# Roadway Plans\_V1.pdf Markup Summary

# CLEARWAY FILING NO. 2, LOT 5

# CONSTRUCTION PLANS

**STORM 1**  
**STA 0+99.84 TO STA 6+72.07**

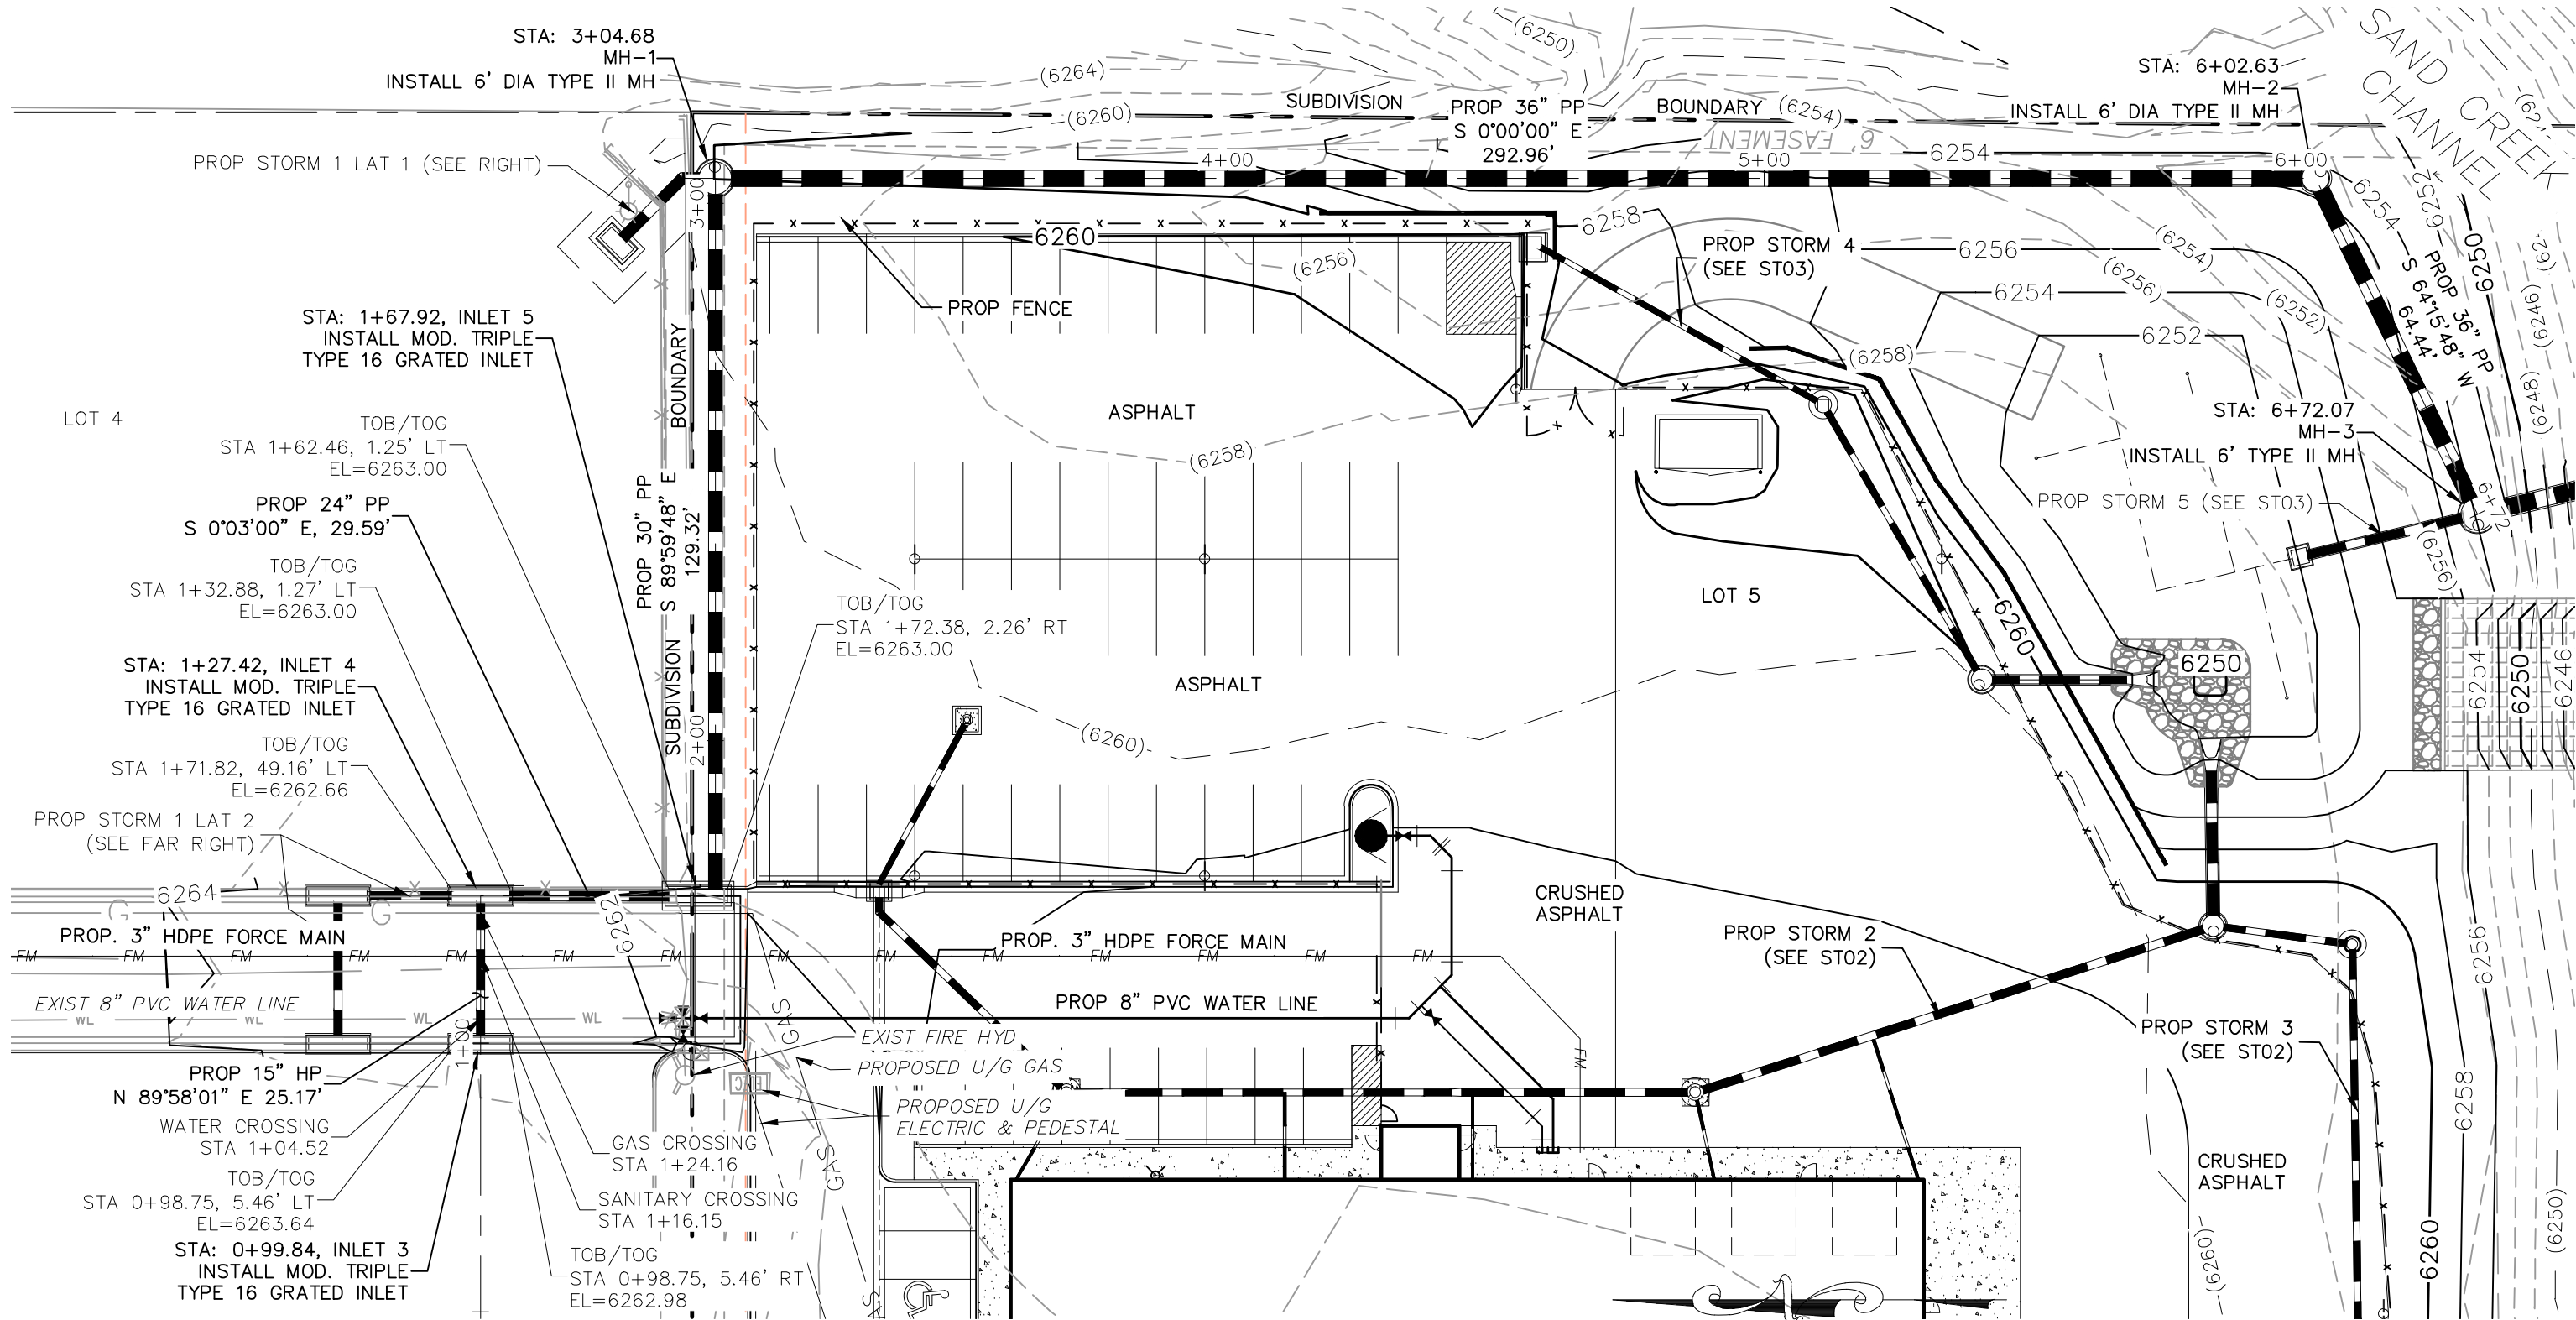
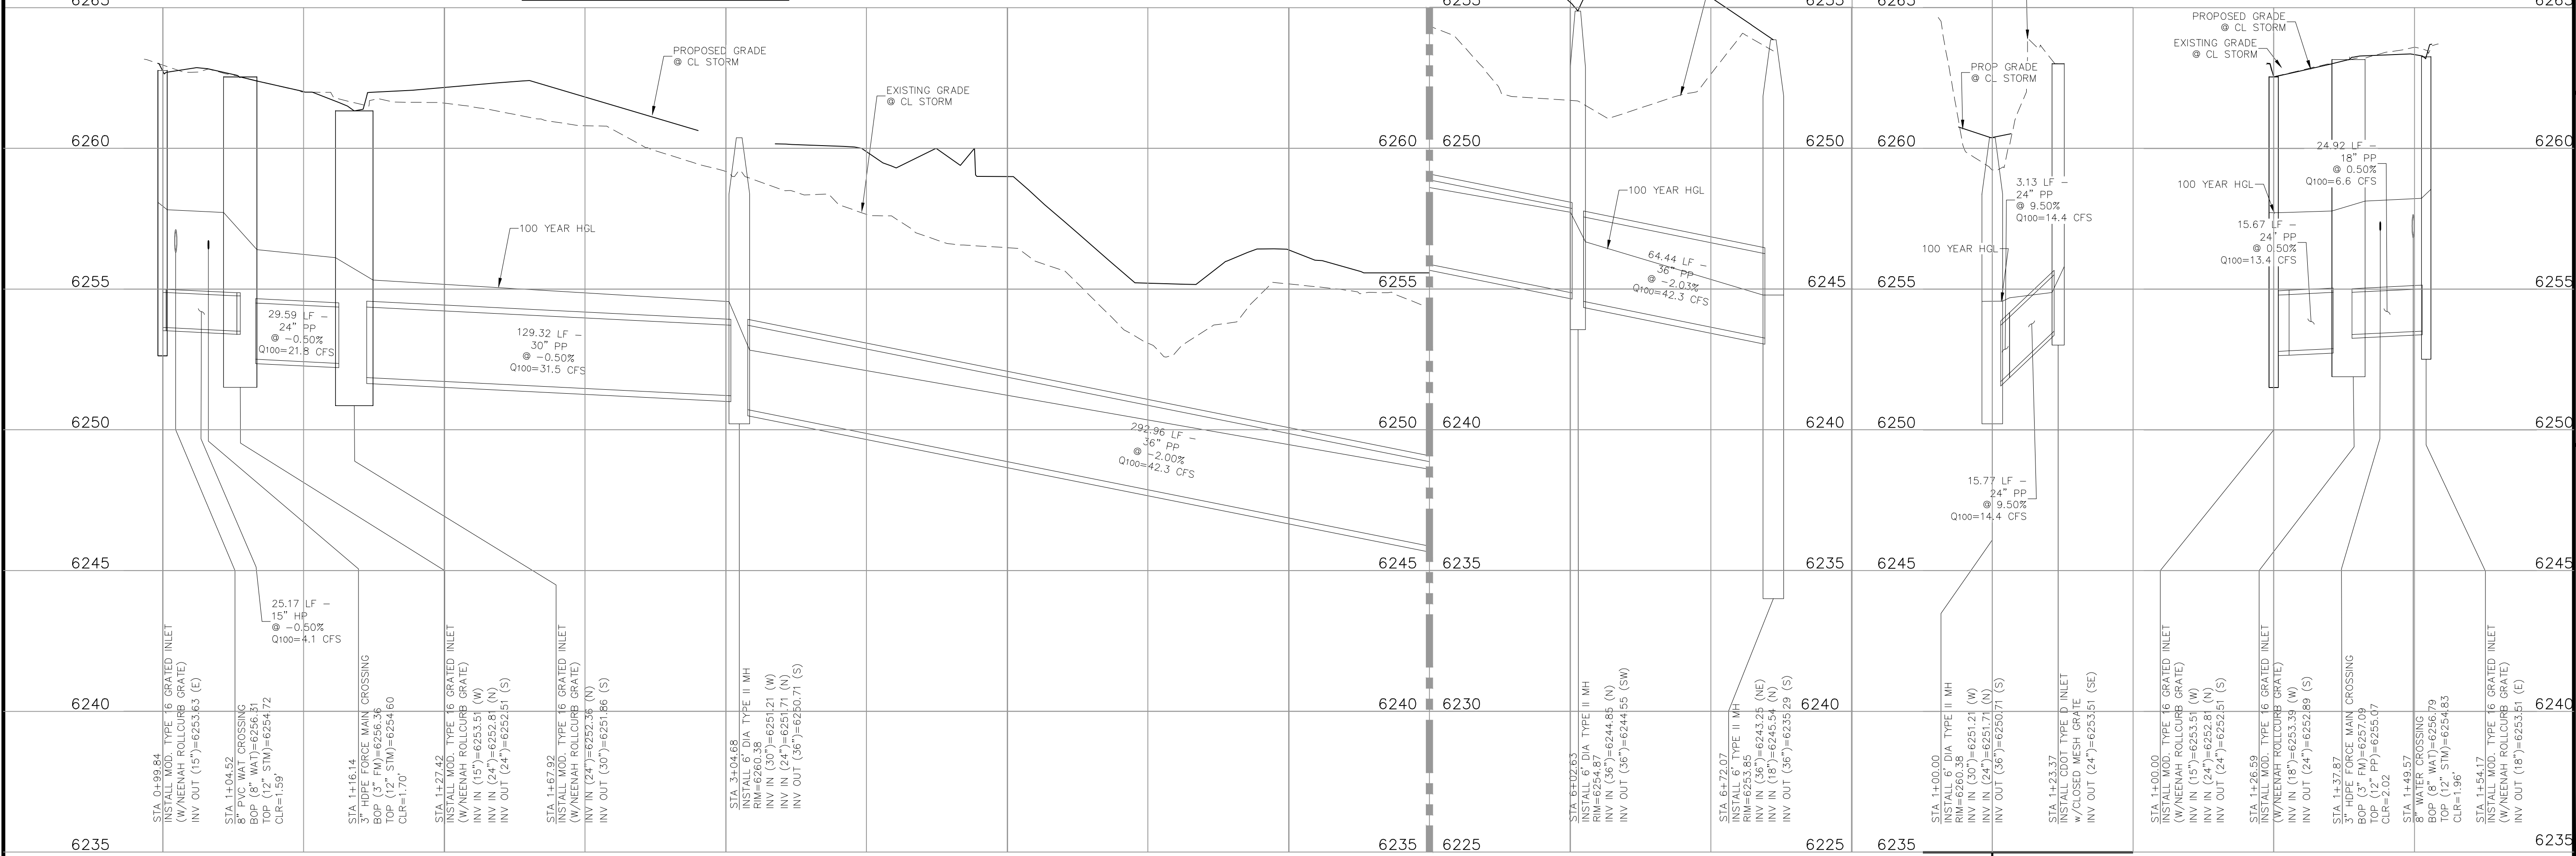
Show HGL lines on the profiles.

identify who will maintain the proposed inlets and storm sewers in the common easement

triple type 16 is indicated on the drainage report. revise.

Typical at all storm profiles.

provide vertical scale
